Submission Form

Epping to Thornleigh Third Track Proposal. Application number SSI 5132.

Figure S.5 Artist's impression of new elevated concourse at Cheltenham Station looking south from The Crescent (indicated by dot)

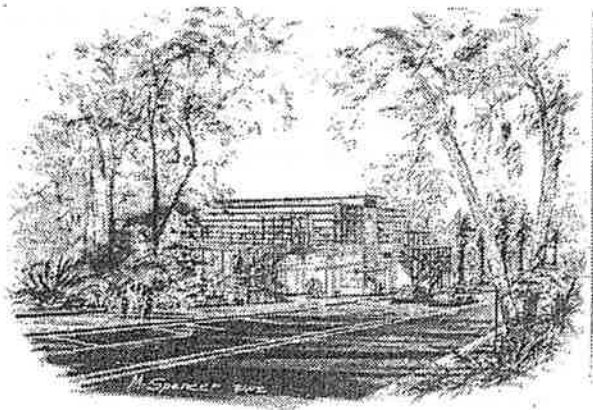
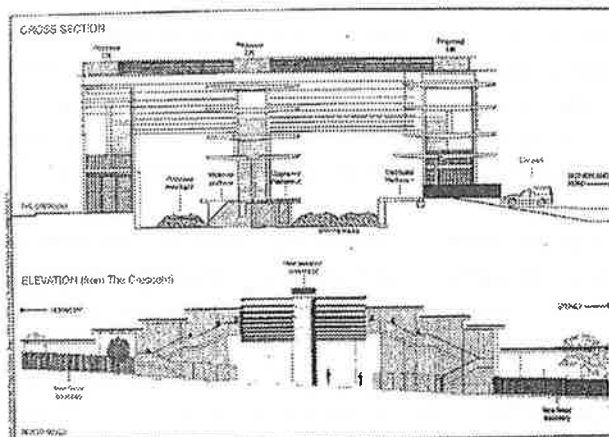
- The proposed redevelopment of Cheltenham Station shows no regard for the HCA. The visual impact of the proposed 13m high glass and steel concourse is totally unacceptable in this HCA.
